**Abel Coal Project Modification (05_0136 Mod 3)
Environmental Assessment Review**

I refer to your email of 21 February 2013 regarding the Donaldson Coal Pty Limited application to modify the consent for the Abel Coal Mine to introduce longwall and shortwall mining methods at the Abel Underground Mine and to extend the life of the mine to 2029.

NSW Trade & Investment, Regional Infrastructure & Services, Division of Resources & Energy (DRE) has reviewed the *Abel Upgrade Modification Environmental Assessment* (EA) and provides the following comments which are directed at specific areas of DRE responsibility for this proposal.

Figure 4: Proposed modified mine plan, including the additional ventilation shaft

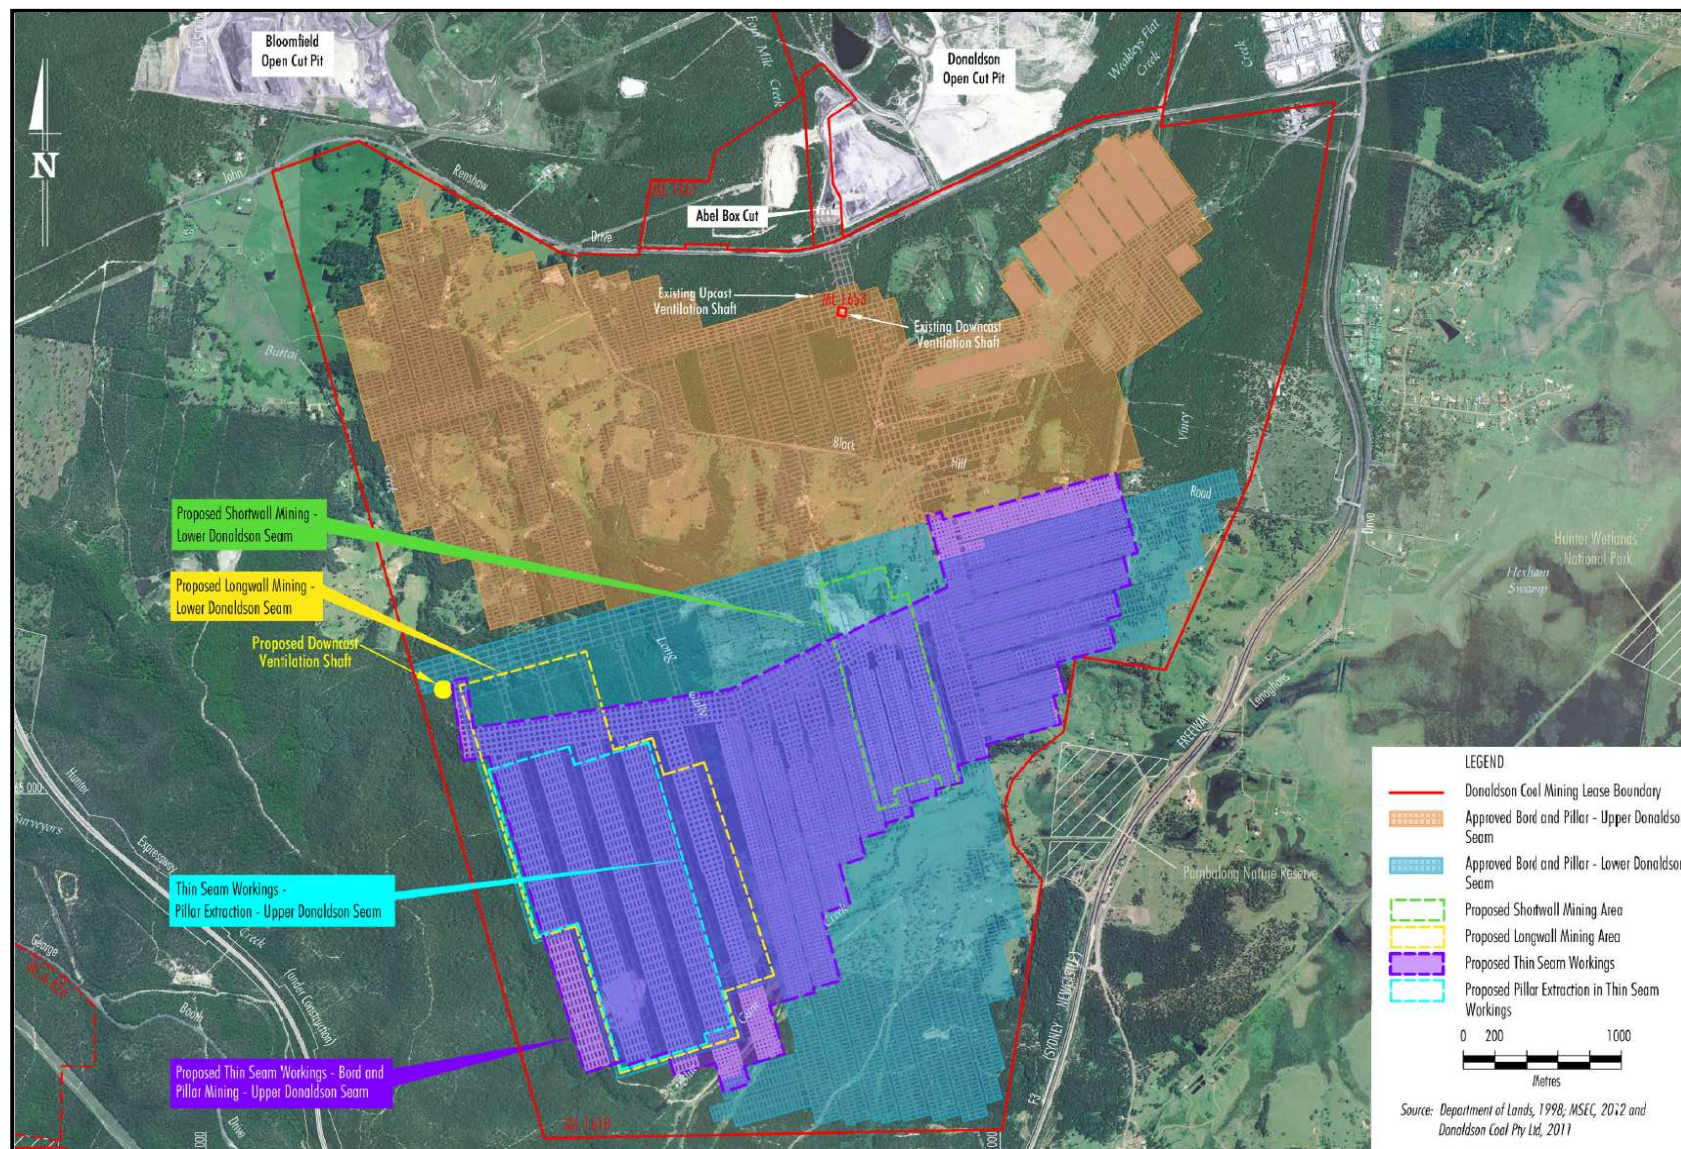
This current proposed modification proposes multi-seam mining, in both the Lower Donaldson Seam and Upper Donaldson Seam in the same areas. As the two seams are separated by approximately 15m of interburden DRE considers that it is highly likely the workings will interact where mining in both seams is proposed, including where first workings only take place. The EA does not include a specific geotechnical engineering assessment of the potential interaction between the relevant proposed workings in the two seams.

No subsidence assessment has been conducted by the proponent for areas of proposed multi-seam mining, i.e. where mining is proposed in the Upper Donaldson Seam over previously approved bord and pillar mining in the Lower Donaldson Seam even though these mining areas are clearly noted as part of the proposed modification in the main report of the EA.

Figure 8: Longwall and Shortwall Footprints and West Borehole Seam Workings

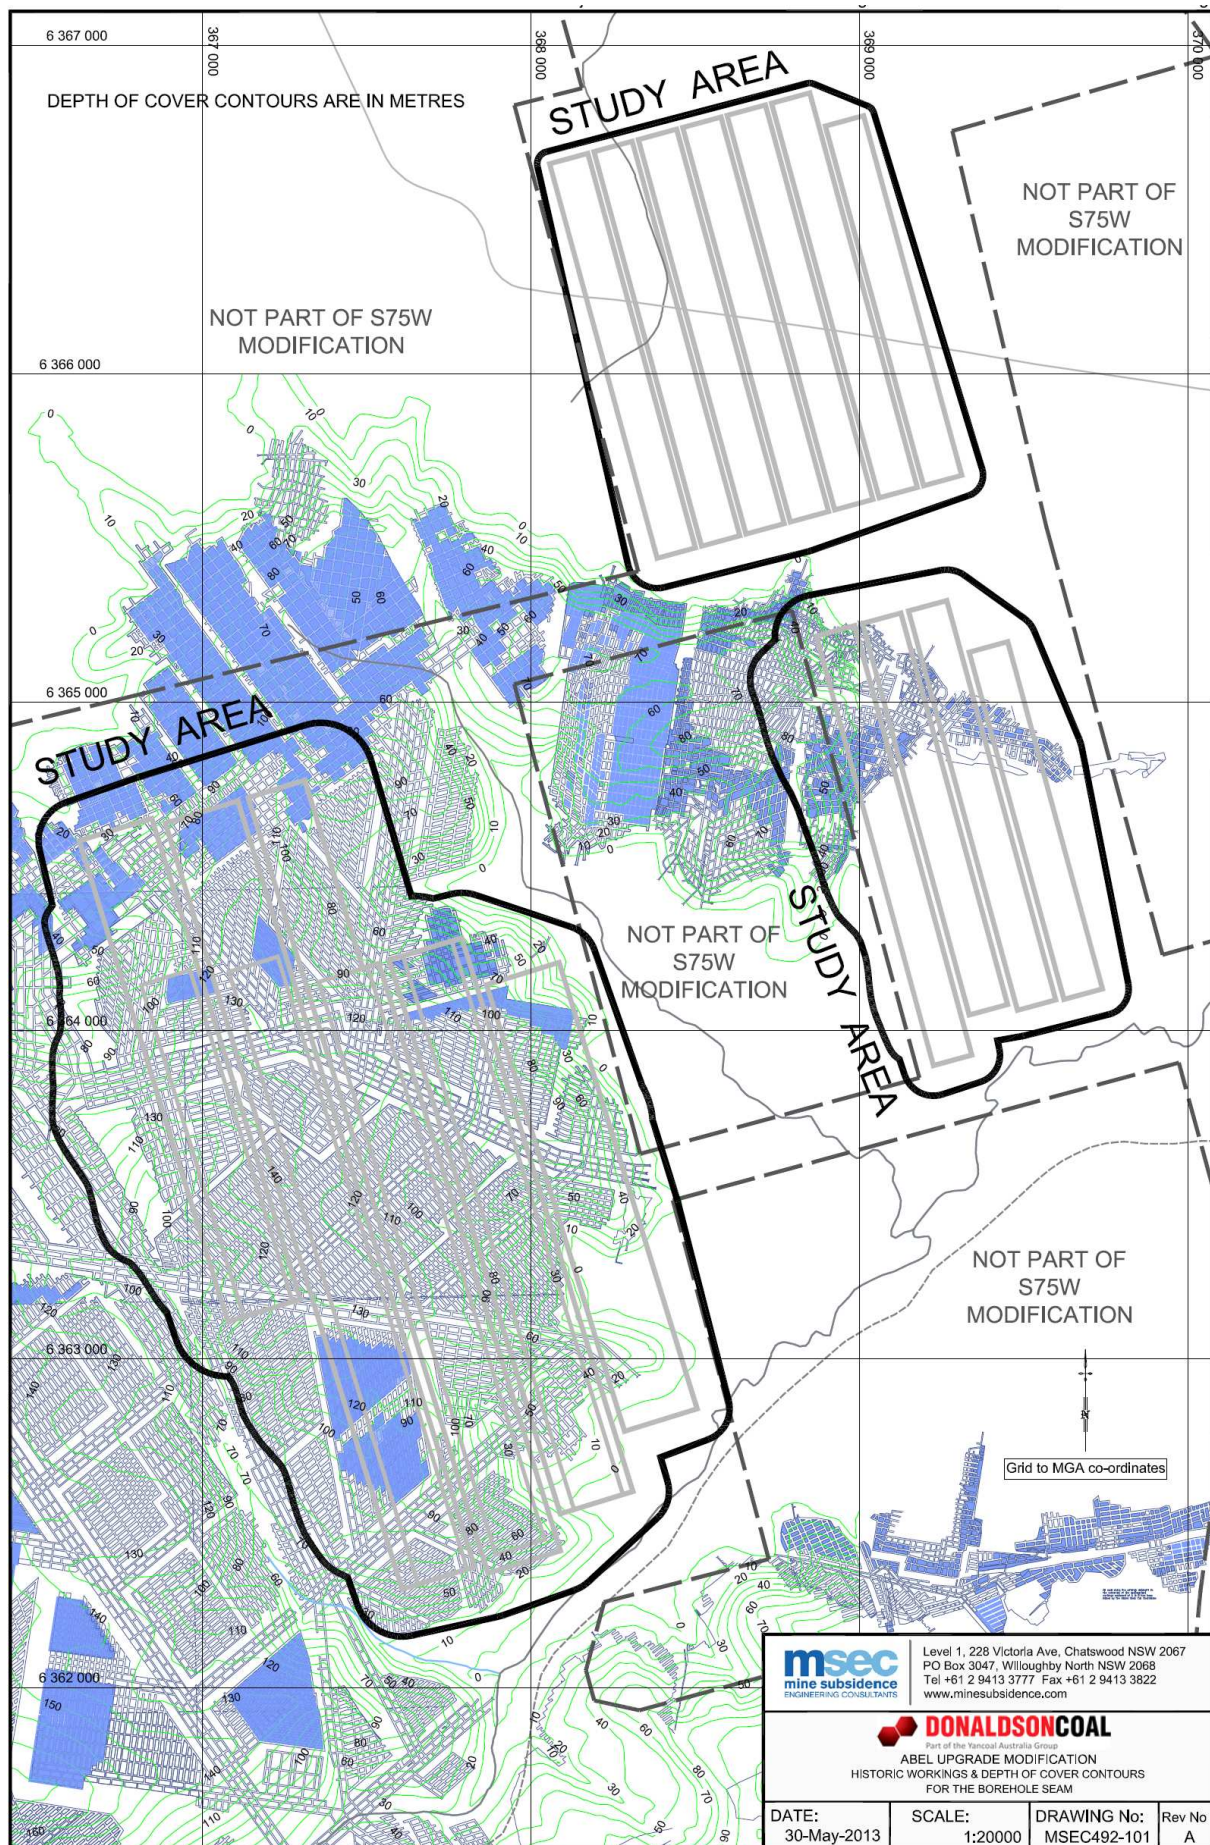
DRE considers that the proponent's current subsidence assessment does not give adequate consideration to the potential for irregular subsidence and for pillar run leading to subsidence outside the angle of draw in areas where old bord and pillar workings are present in the Borehole Seam (i.e. propagation of instability of old bord and pillar workings beyond the normal subsidence limit above the proposed mining).

There is considerable uncertainty in relation to the current condition of old bord and pillar workings in the Borehole Seam including the accuracy of official records and plans of the workings.

In relation to old bord and pillar workings, DRE's input into the Director General Requirements (DGRs) dated 14 February 2012 specifically recommended the assessment and investigation of such workings in relation to any identified significant surface features. No assessment and investigation of old pillar workings has been undertaken for the EA, however DRE note that the subsidence consultant's report in the EA recommends that this should be done.
